Lawful Development Certificate for a Proposed Use or Development

Development: Lawful development certificate for a proposed infill extension between garage and main house.
Location: 5 Church Lane Pagham PO21 4NS

PART GROUND FLOOR
PLAN. [AS EXISTING.]
1:50 @ A3.

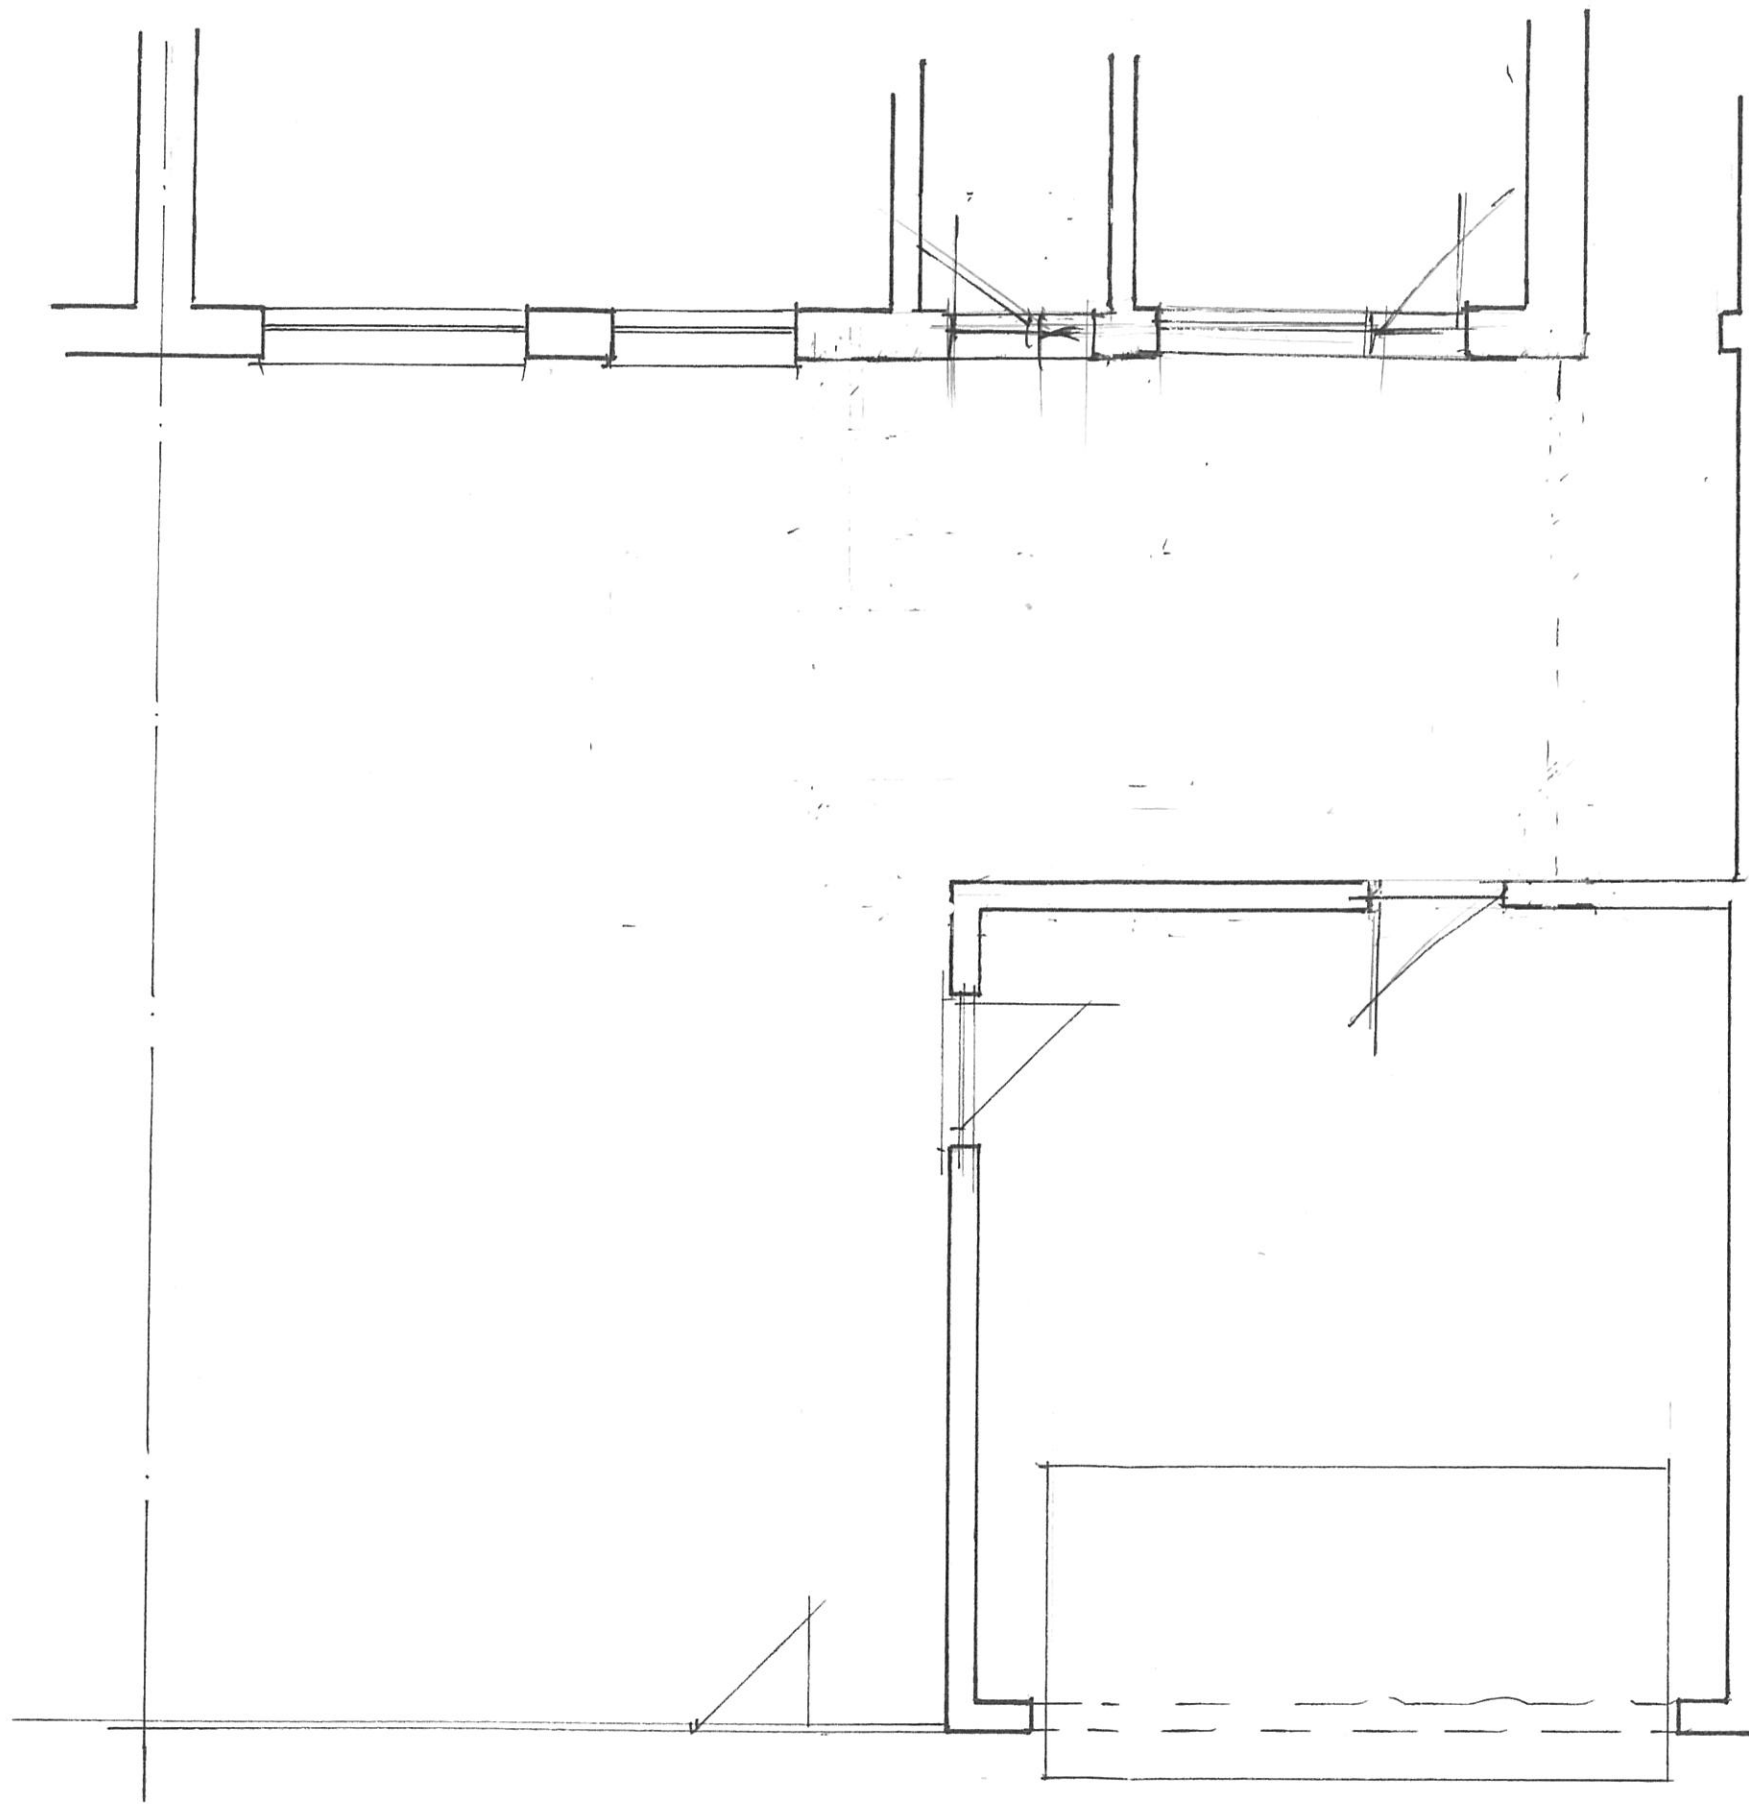
Please provide an existing floor plan.
